**KIRKLEES COUNCIL
TOWN AND COUNTRY PLANNING ACT 1990
HIGHWAYS DEVELOPMENT MANAGEMENT**

PLANNING REF 2018/62/92347/E0/WS
CATEGORY Minor

PROPOSAL PARTIAL DEMOLITION AND
CHANGE OF USE OF GROUND
FLOOR AND LOWER GROUND
FLOORS TO OFFICES AND
EXTERNAL ALTERATIONS(WITHIN
A CONSERVATION AREA)
LOCATION 92 NEW NORTH ROAD
EDGERTON
HD1 5QP
APPLICANT LARCHE
DEVELOPMENTS(YORKSHIRE)LTD

DRAWING DESCRIPTION
Car Park - Swept Paths
1 of 2

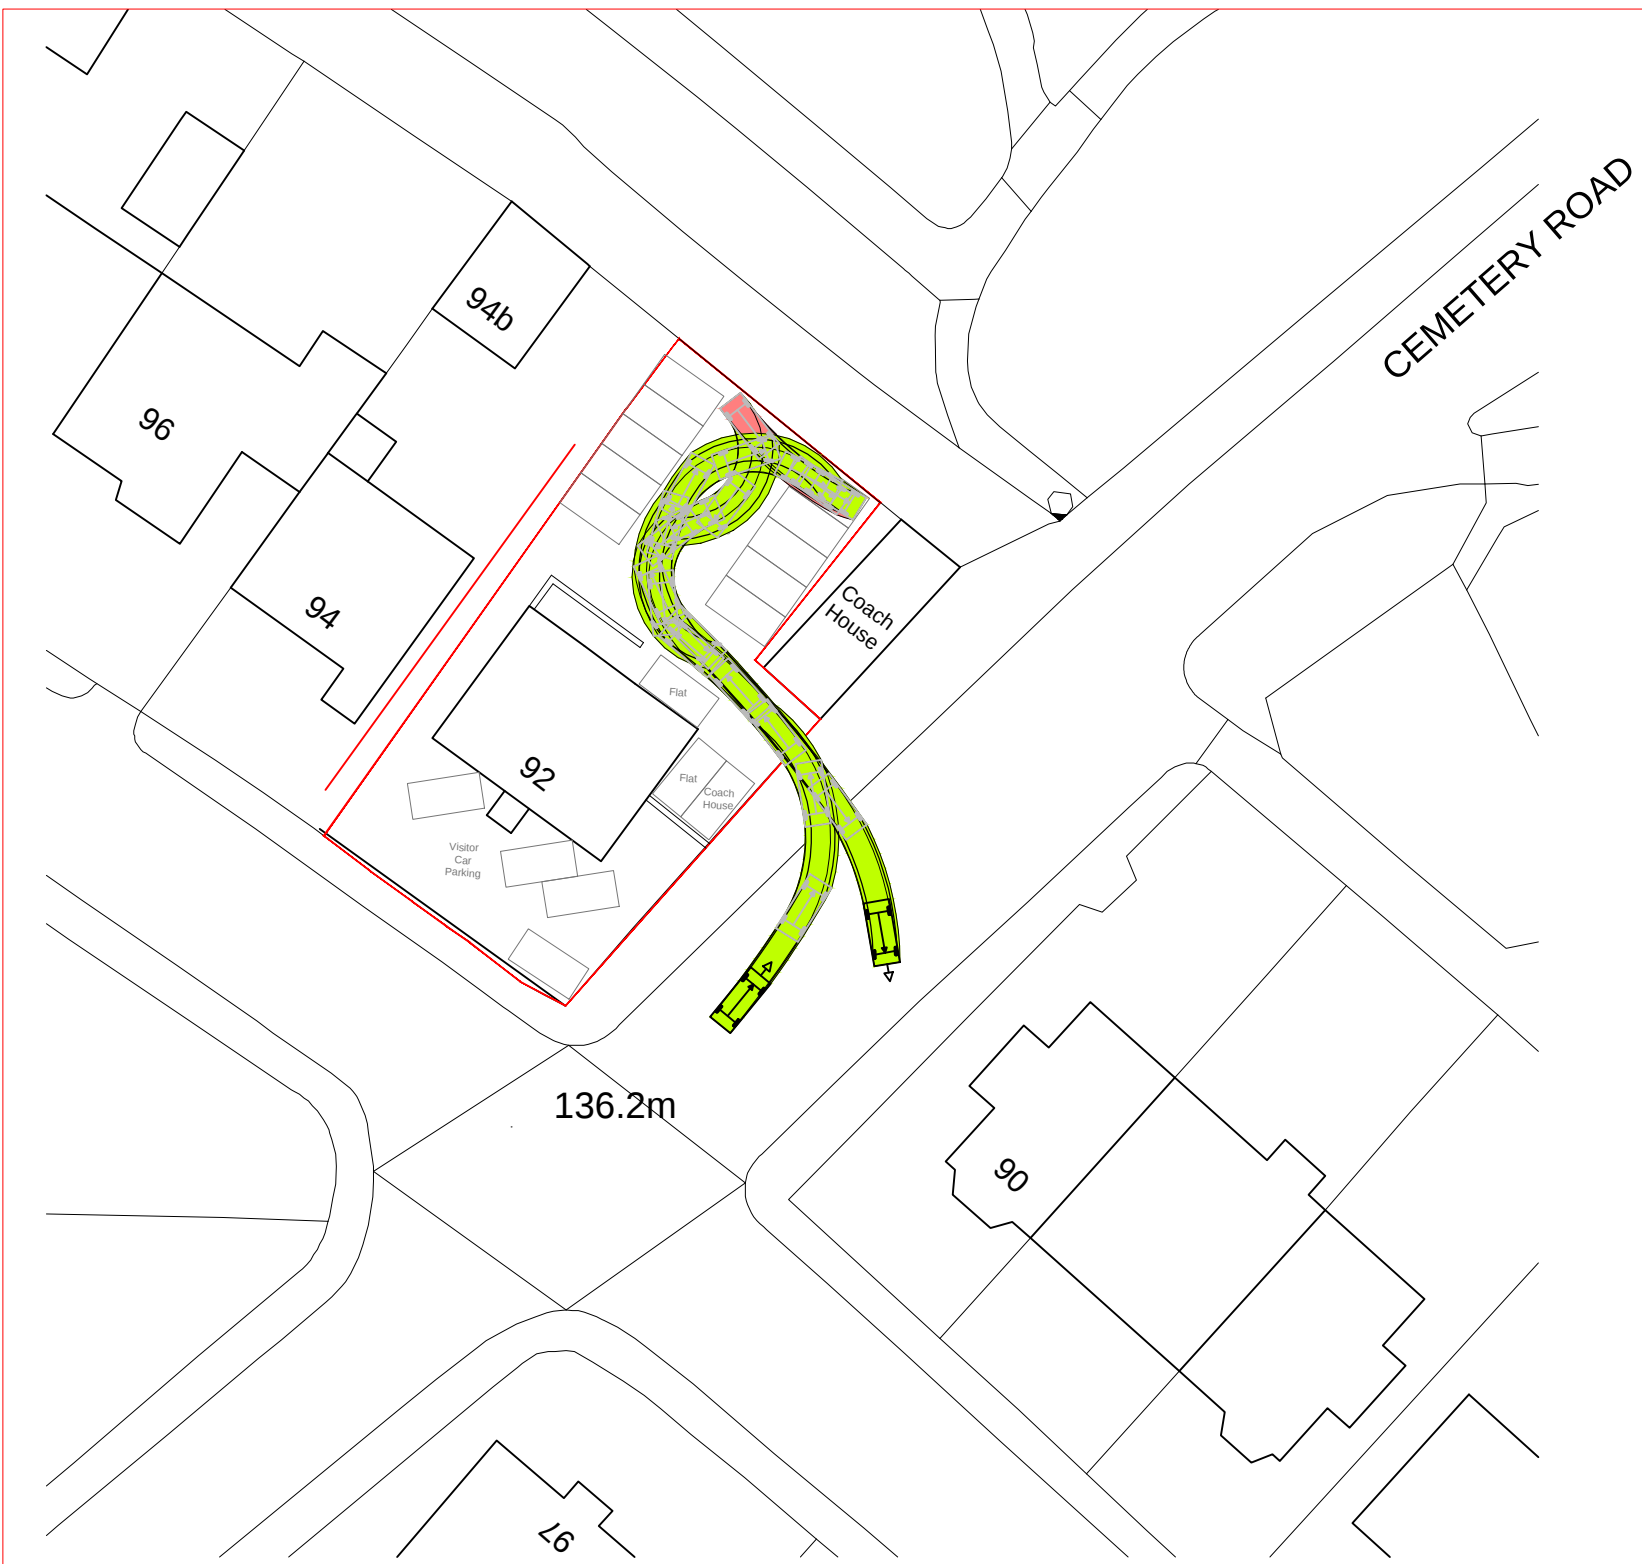
On-site observations showed that cars do not currently park to the front of the site in the echelon manner shown, and the recommended distance of 6m between the bay and the house frontage to allow for turning cannot be achieved. It is likely that egress from these spaces will be extremely difficult, especially without using third-party land. A similar issue with manoeuvring space occurs at the parking to the rear.

- Swept path analysis of a vehicle entering and exiting the site from the proposed parking bays (in particular spaces 10, 12, 5, and 6).
- Provision for the storage and collection of waste marked on a plan.

Swept-path analysis has been provided showing vehicles being able to access and egress the site on a forward gear. As such, these proposals are now acceptable from a highways perspective and Highways DM has no wish to raise objection to the scheme.
